**Application: SSD 8703**

**Location: Tallagandra Lane, Sutton**

**Proposal: Solar Farm**

Further to Yass Valley Council's preliminary submission dated 30 July 2018, an addendum to this submission is provided following the resolution of the 22<sup>nd</sup> August Council Meeting to incorporate the following matters:

Figure 9: Visual receptor locations

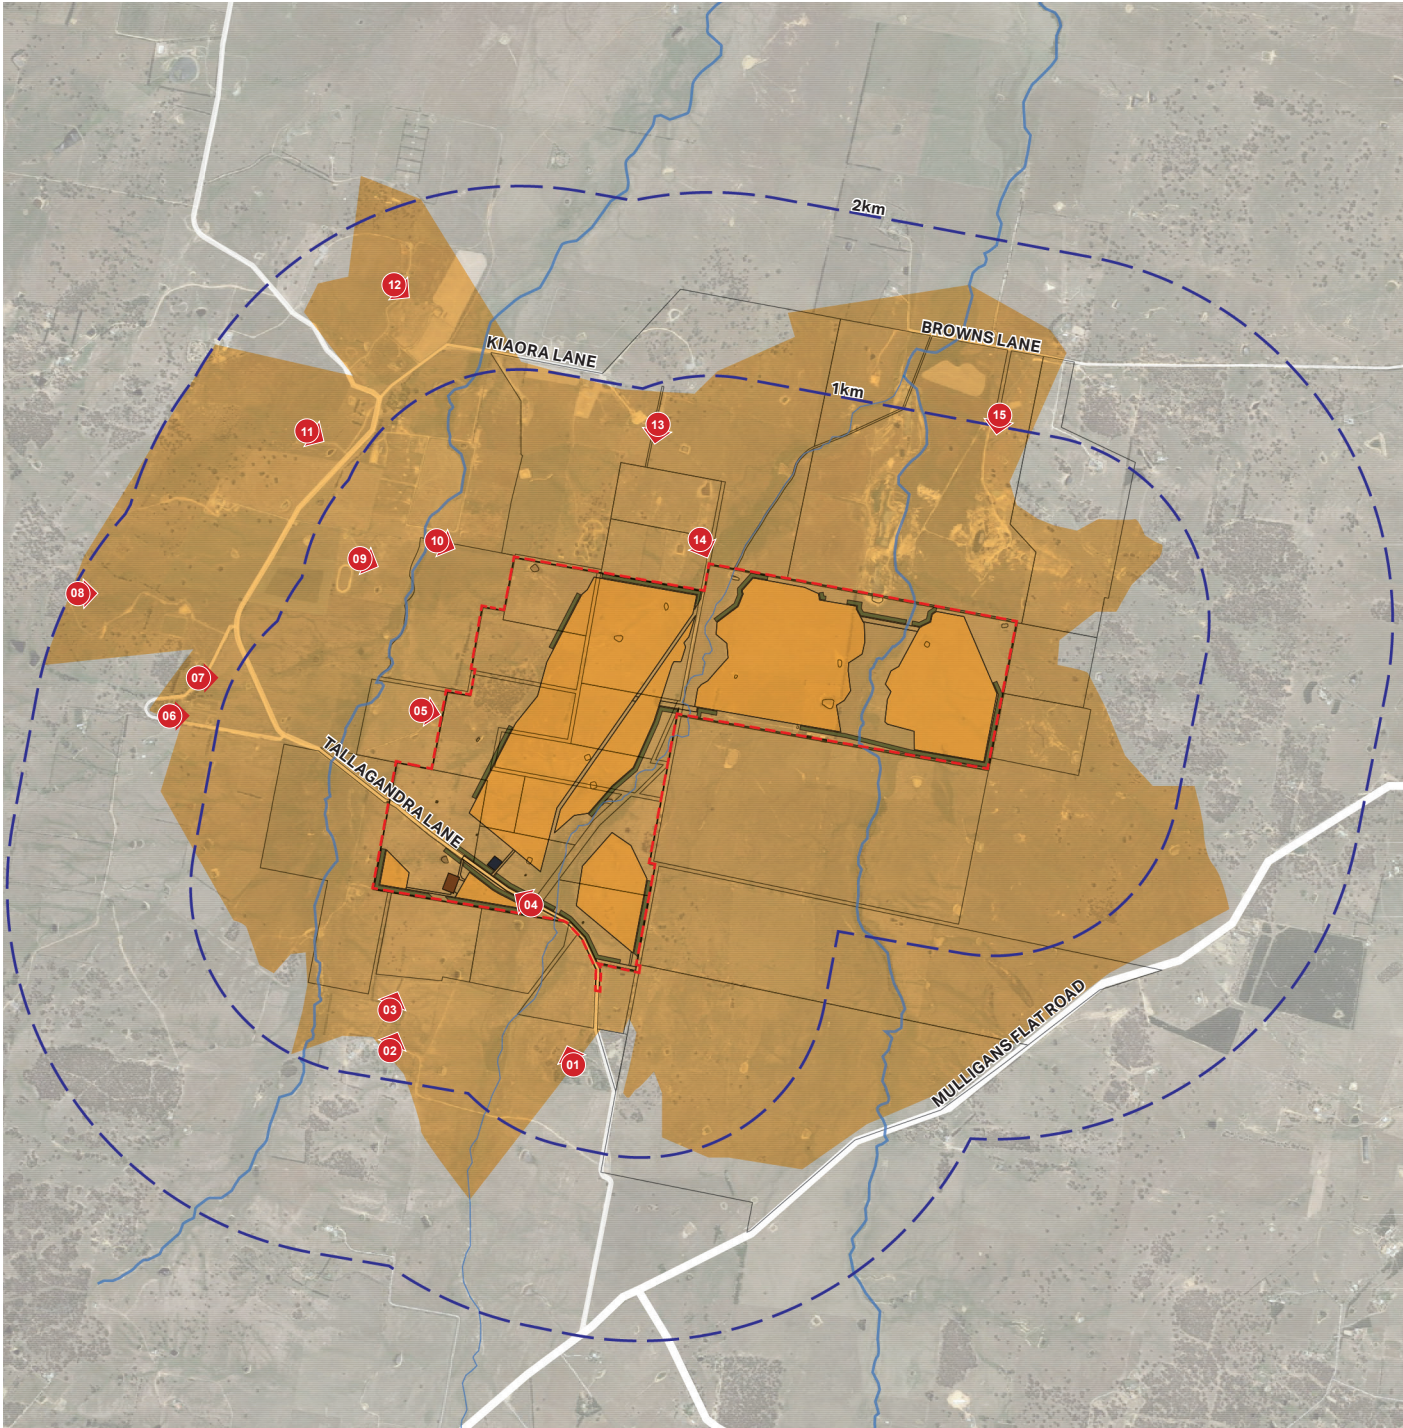
- The visual assessment is to be revised to include all affected dwellings within 2 km of the site.
- The project is to demonstrate how it positively contributes to the habitat connectivity outcomes of the Greater Gooroyaroo project.

DETAIL 1: SCREEN PLANTING - TYPICAL PLAN 1:200

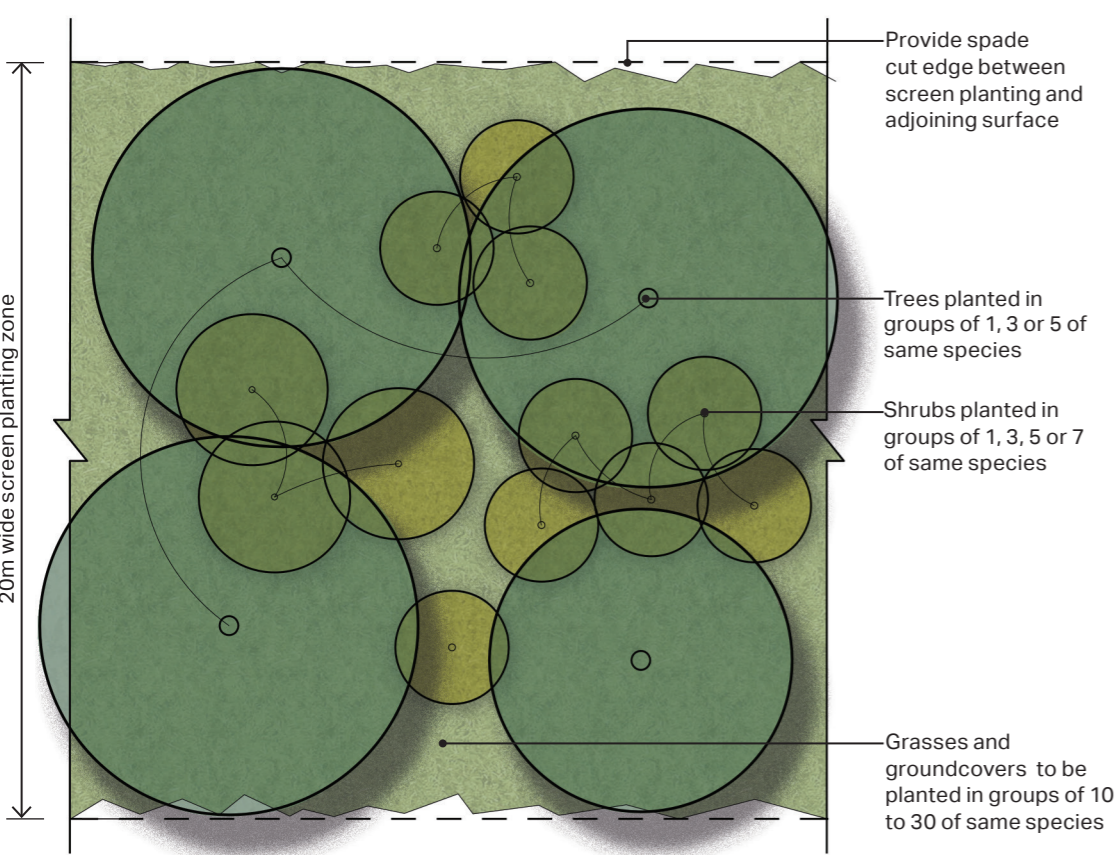
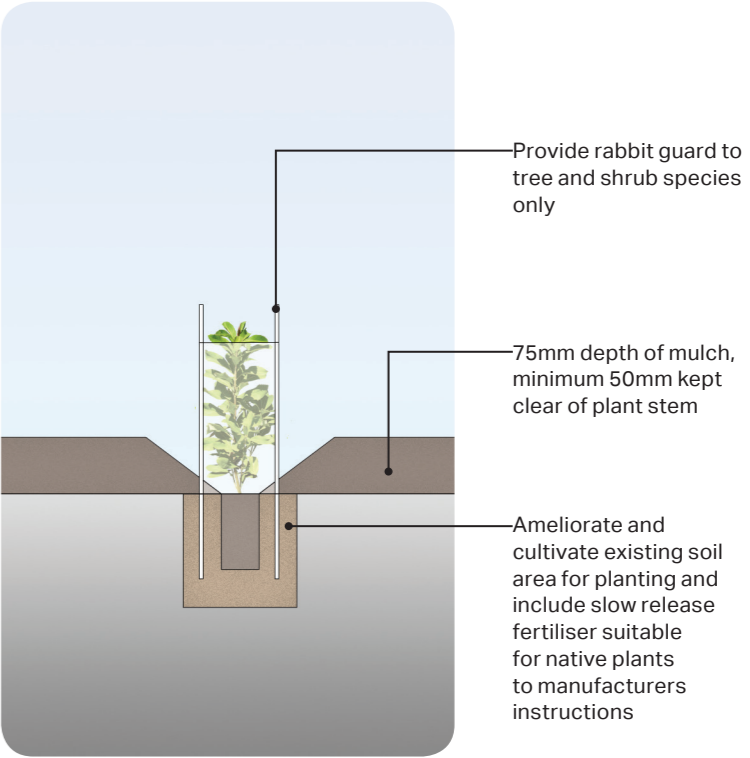
- If approved, the proposed 2.2 metre high security fence is to be located inside the 20 metre wide landscape strip rather than on the boundary to Tallagandra Lane and Tintinhull Road.

- If approved, the project is to be commenced within 5 years of a Consent being issued and completed within 5 years of commencement.
- If approved, any landscaping plan is to incorporate species which are endemic to the local area.
